Application for a Non-Material Amendment Following a Grant of Planning Permission

Construction of nine dwellings and associated works

20/02915/FU

HOUSE TYPE F - PLANS

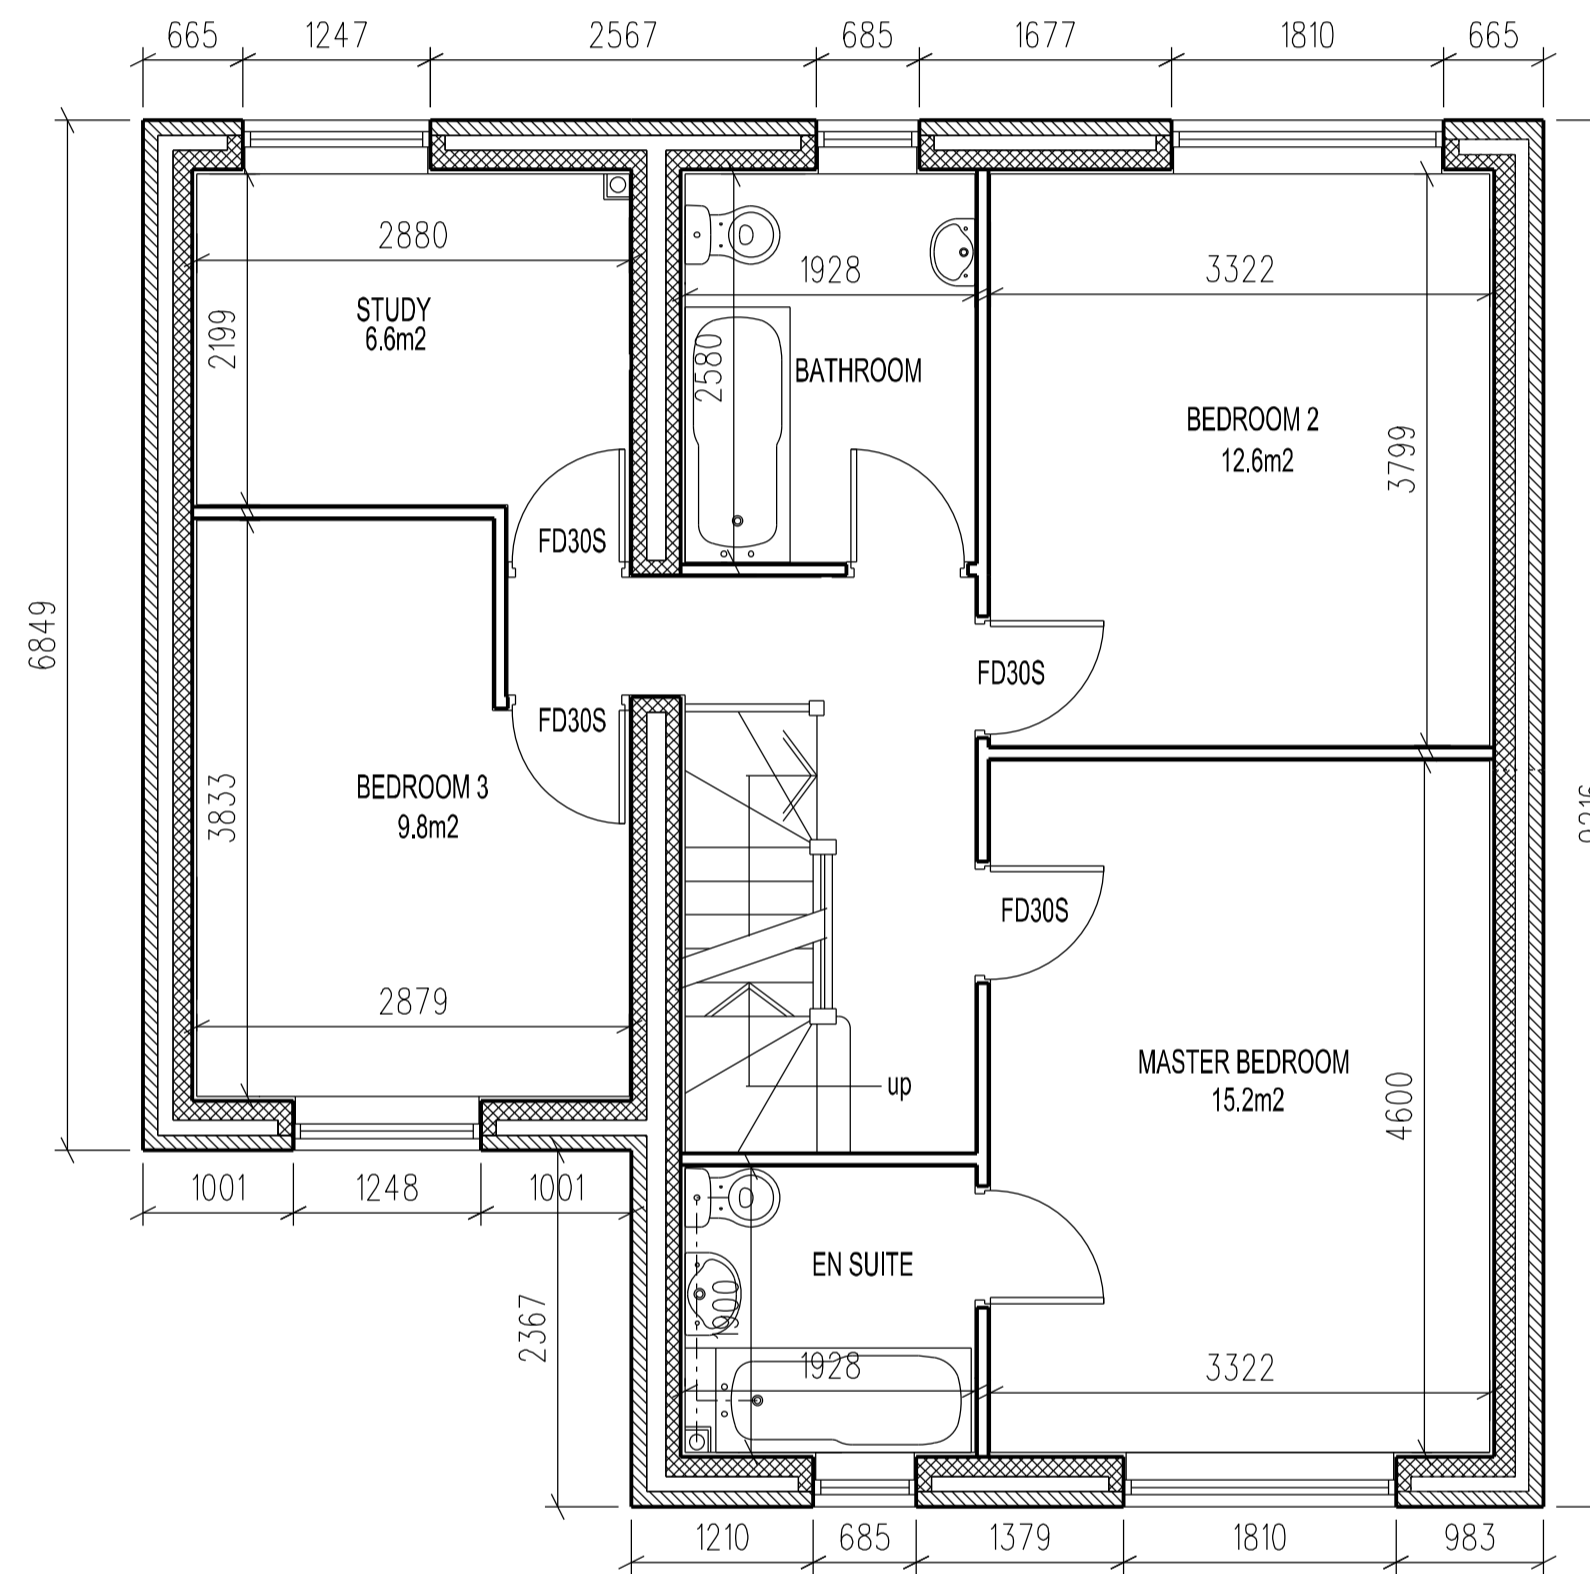
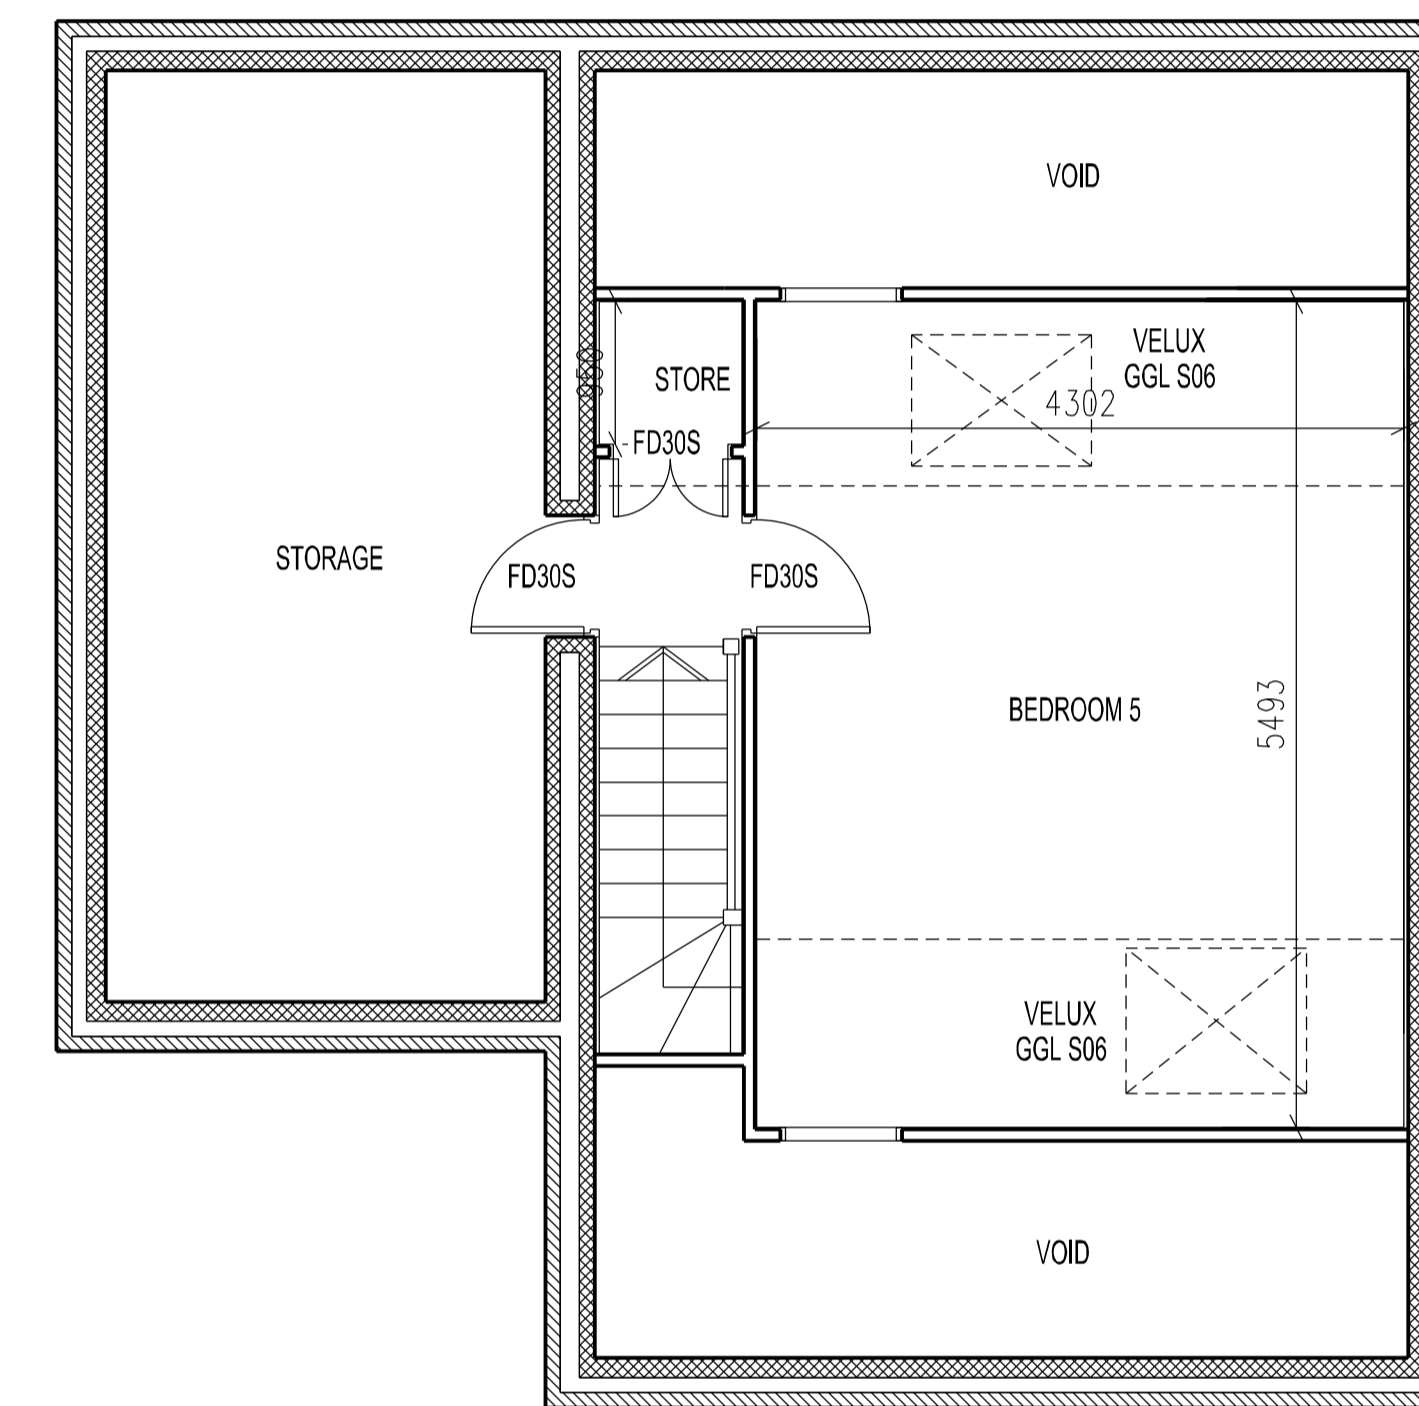
There has been an added ground floor garage to both house type C and house type F as well as an increase in floor area to both of these houses.

House Type F plans replaced with rev J
